Planning Application Ref: EG/22/19/OUT

Location: Boweries, Barnham Road, Eastergate, PO20 3RT

Description of works: Outline application with some matters reserved for the erection of 28 No. dwellings, access, landscaping & associated works (resubmission following EG/42/18/OUT).

Tree Officer / Parks and Greenspace Team

client			
Domusea Limited			
project			
The Boweries Barnham Road Eastergate			
title			
Proposed Site Layout Plan			
date	scale @ A3	drawn	chkd
May 2018	1:1000	KWF	MRL
project no.	drawing no.	rev	
1815	101	P03

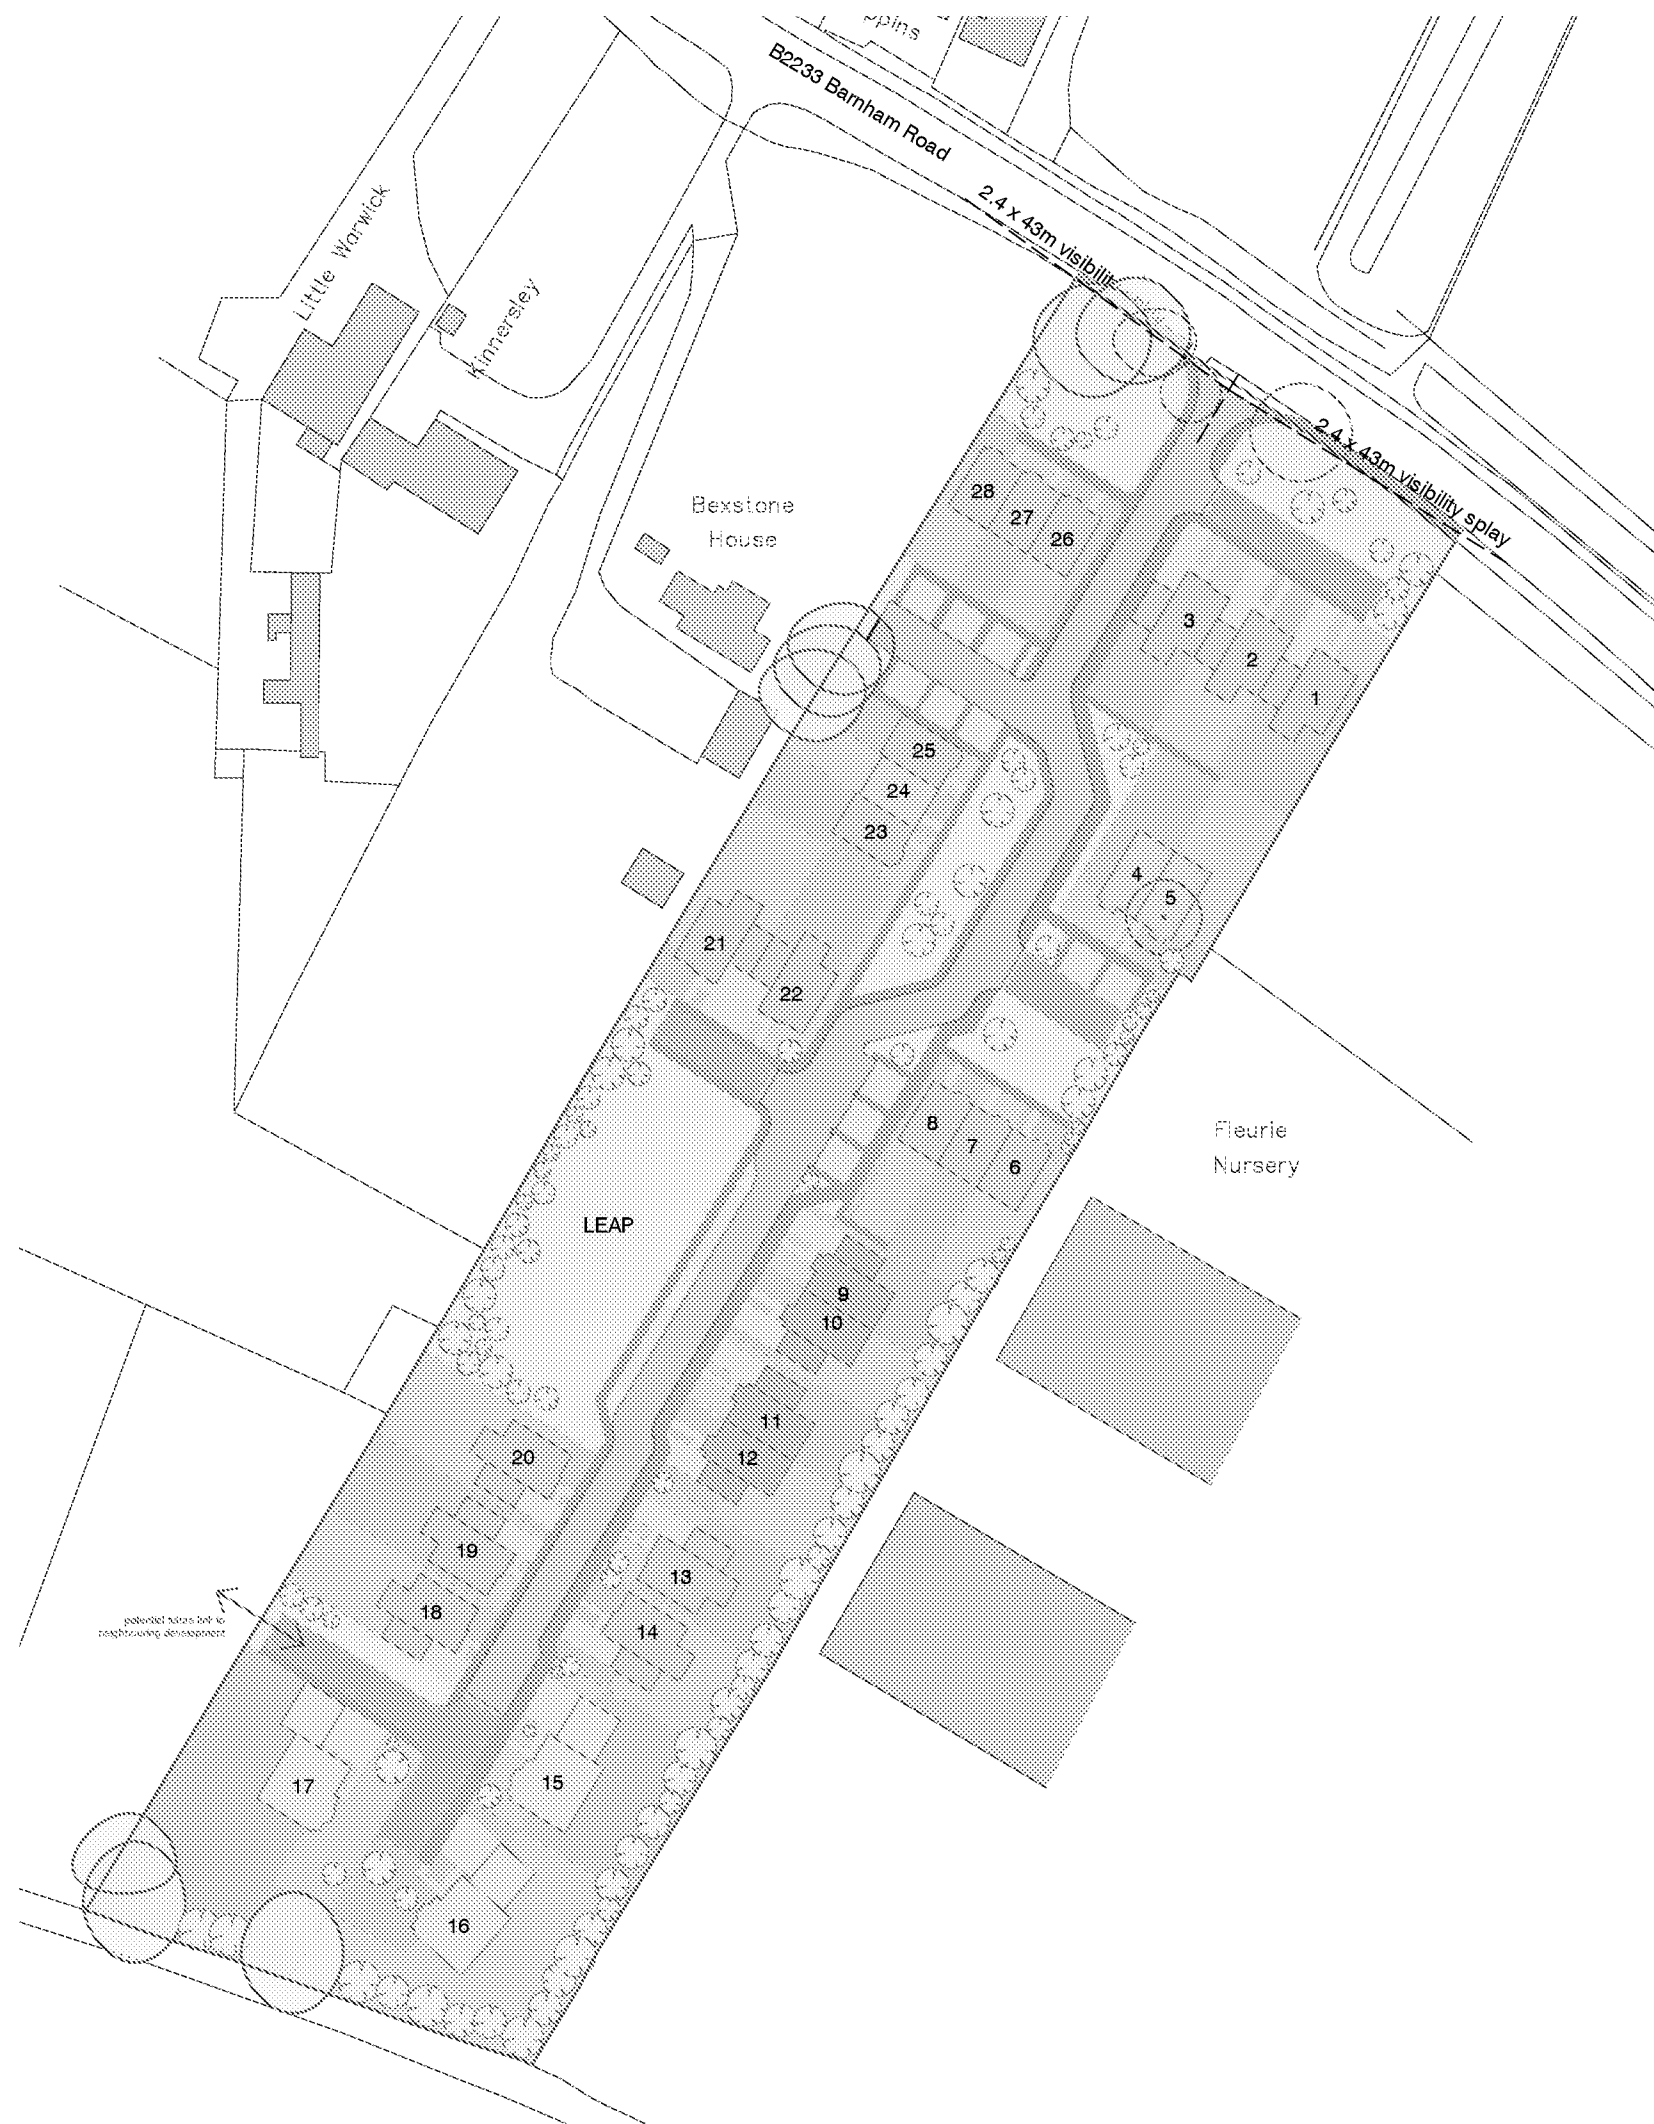
- The proposed access to the site would involve the removal of three mature trees of high public amenity value. I find this unacceptable and would expect a revised layout to accommodate those trees (recommended to be the subject of an Order) sympathetically. As such, the logical alternative for site access would be due east of T45 and its nominal root protection area (RPA).

- There are useful (ecology/screening) and visually interesting tree groups (landscape/amenity value) on the west boundary of the site, TL07 and TL19. While not individually or collectively worth of an Order (TPO), I would expect them to be accommodated in any proposed layout, with ample room so as to allow their unrestricted growth and existing nominal RPAs to be undisturbed.

- Large and prominent trees along the south boundary of the site TL01, TG02 & T03 are also useful for the reasons stated above and perhaps of greater significance for the wider area. These appear to have been given adequate room in the current proposed layout, which I would expect to remain a primary consideration.
